CITY OF ALBUQUERQUE

RE: 2818 4th Street NW Apartments
Grading & Drainage Plan
Engineer's Stamp Date: 05/18/20
Hydrology File: H14D111

Based upon the information provided in your submittal received 05/19/2020, the Grading & Drainage Plan **is not** approved for Building Permit, Grading Permit, SO-19 Permit, and for action by the DRB on Site Plan for Building Permit. The following comments need to be addressed for approval of the above referenced project:

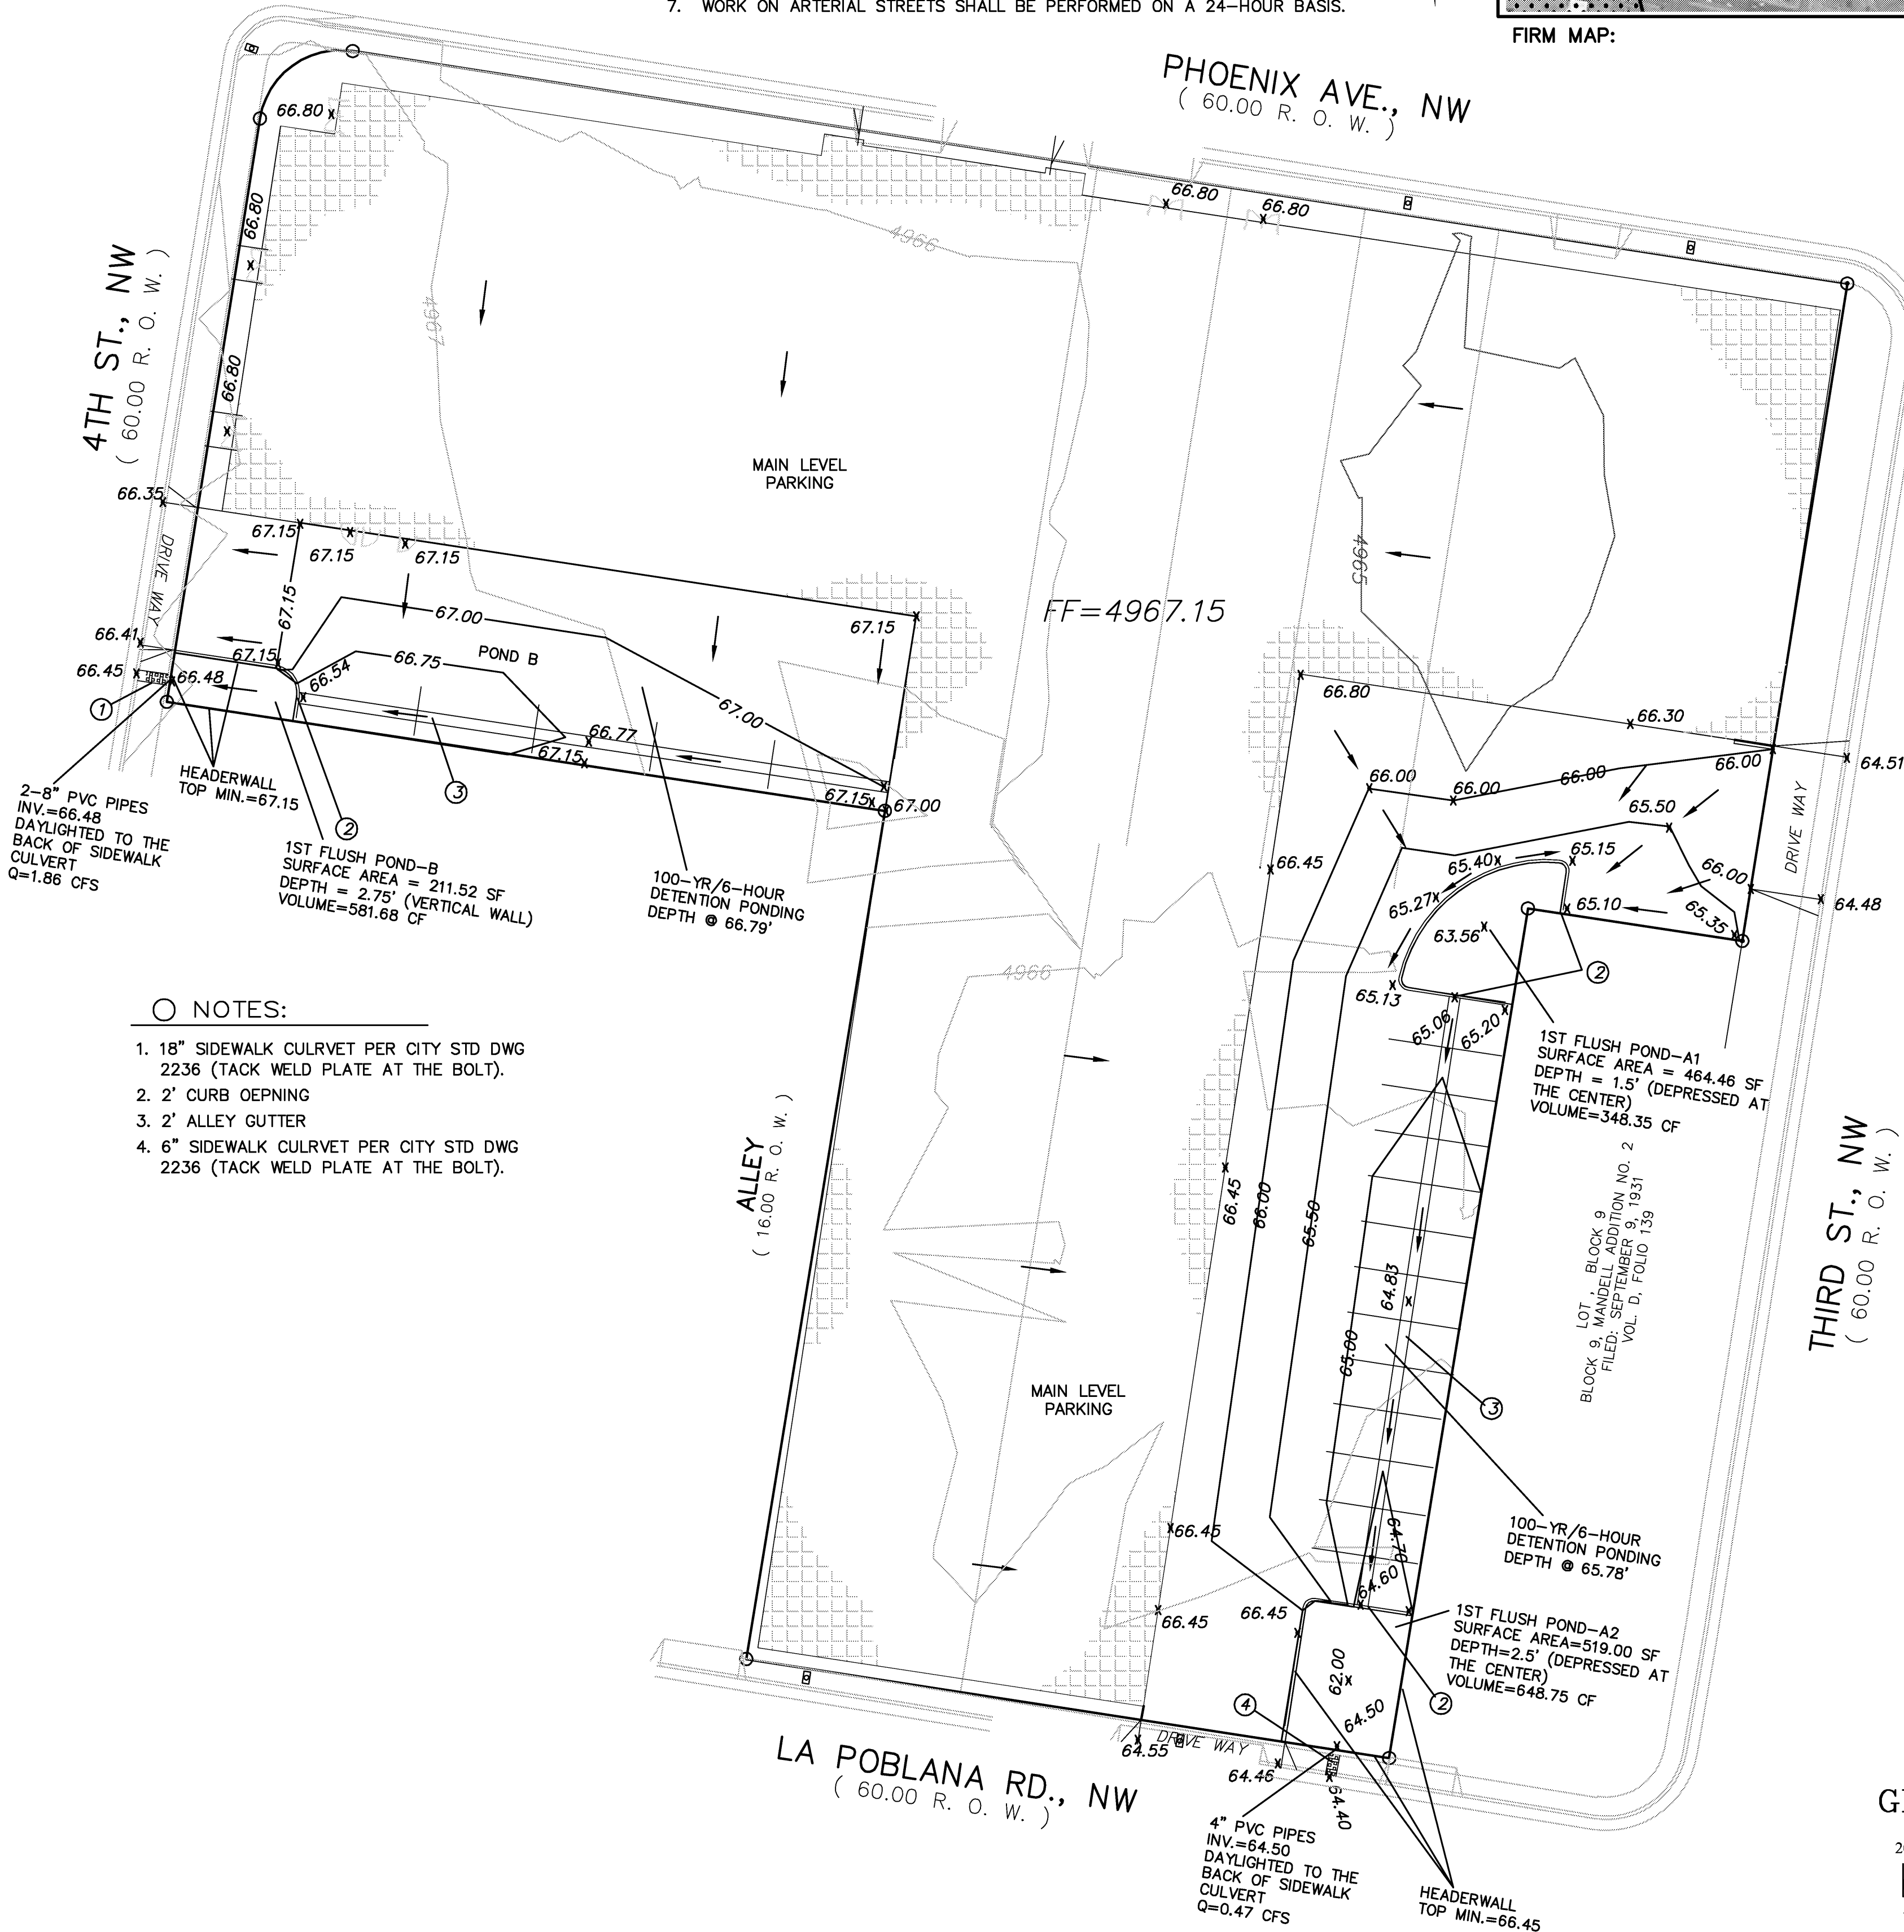
1. Please include project benchmark and datum for the survey information.
2. Please provide the latest SO-19 notes. These have been attached.
3. Please move the callout text for the outfall pipes on La Poblana Rd. This is right on top of the road name and is unreadable.

4. Please provide a cover sheet with an engineer's stamp with a signature and date for the drainage calculations.
5. Please provide the weir calculations for the two feet curb cuts, per DPM Chapter 22.3.A.1. A coefficient of 2.7 is typically used for the weir equation $Q = CLH^{2/3}$.
